Consultation Response from KC,  
Lead Local Flood Authority

2023/93782 14, Firth Street, Huddersfield, HD1 3BA

Erection of extensions and alterations to form 16 student apartments

Date Responded: 14/03/2024.

1 Lower Ground Floor Plan
1 : 100

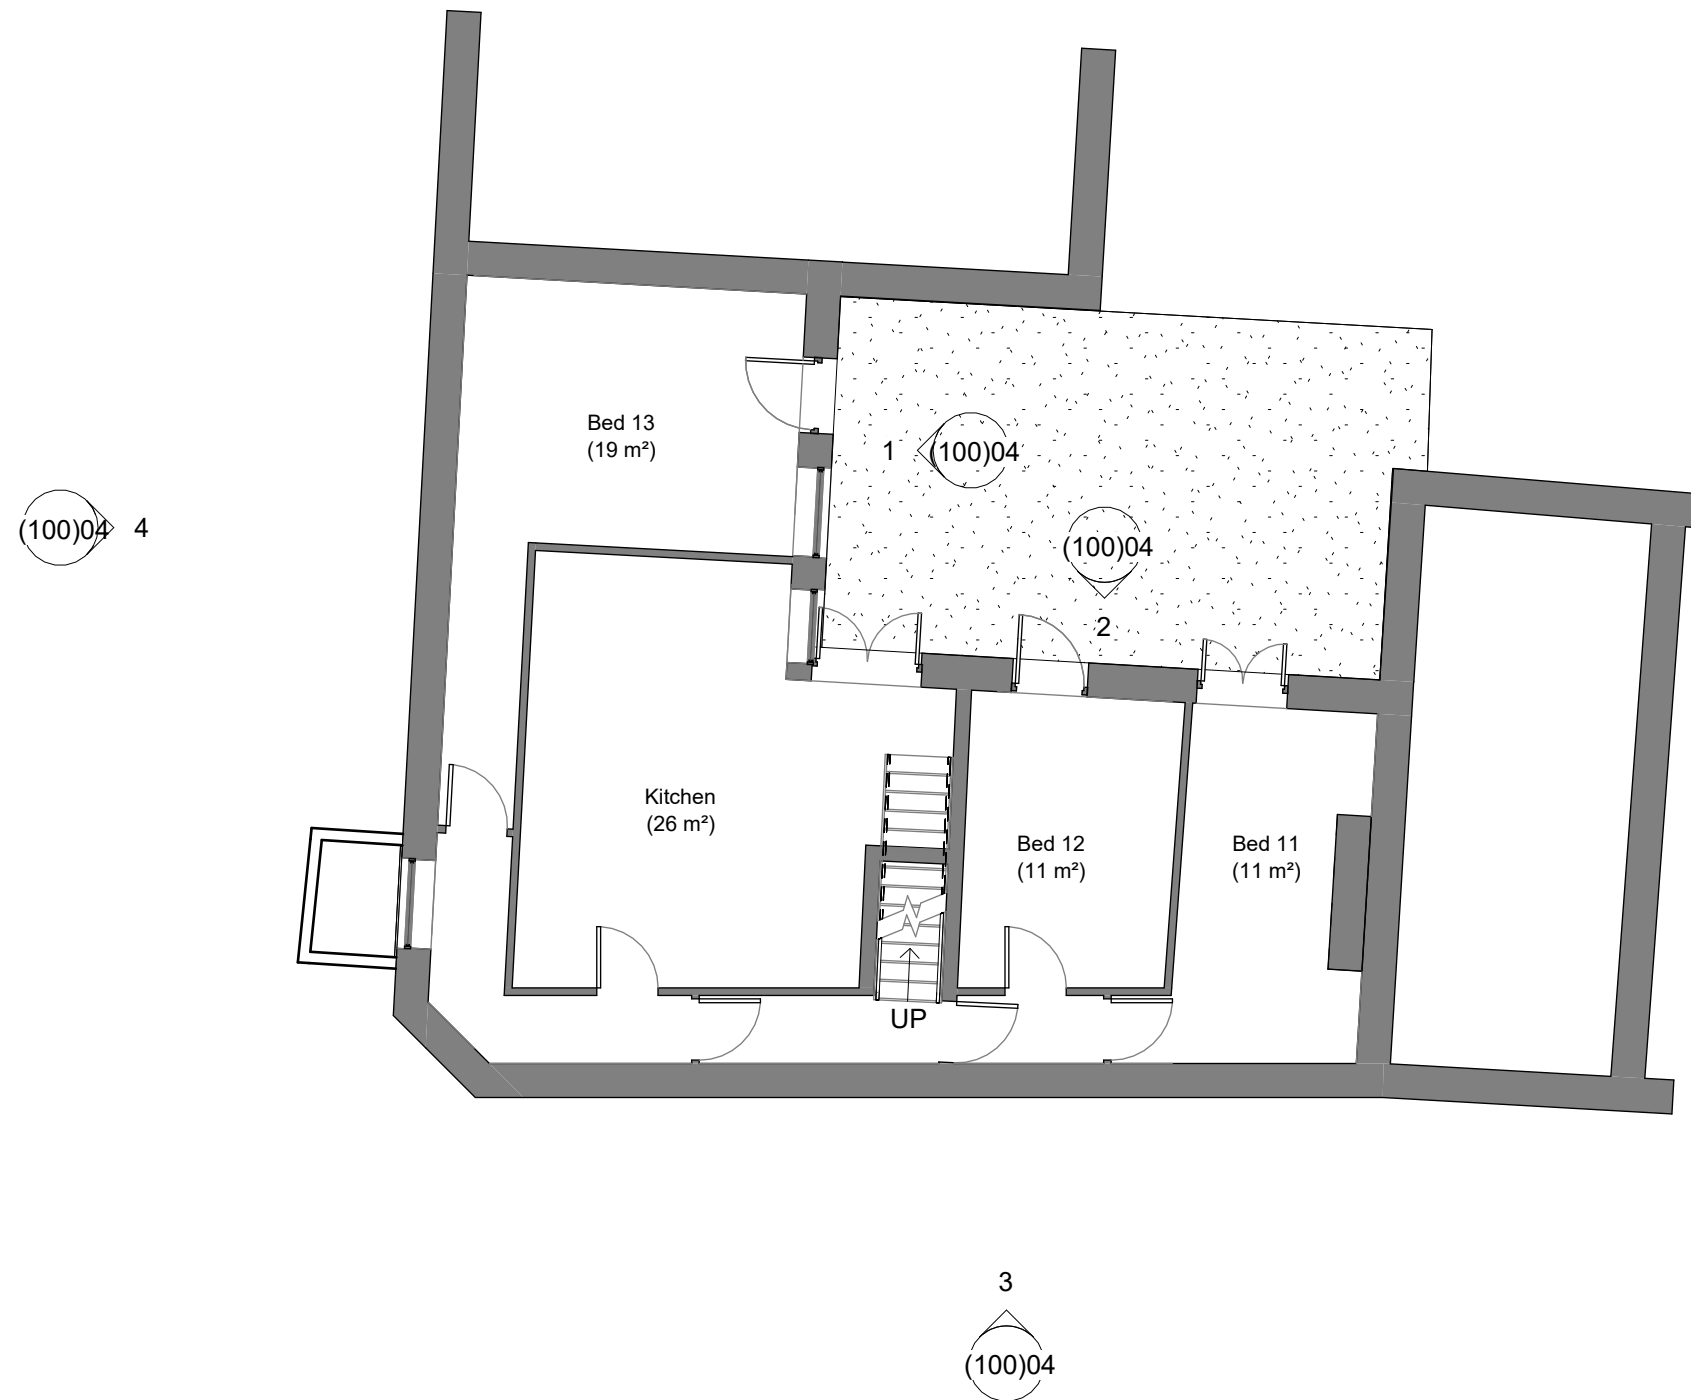
It is noted that one of the flats is located below road level and that the building is in Flood Zone 2. It is recommended that the developer produces a specific **Evacuation Plan** for the occupant of this flat in the event of floodwater entering the flat due to heavy rain or high river levels.
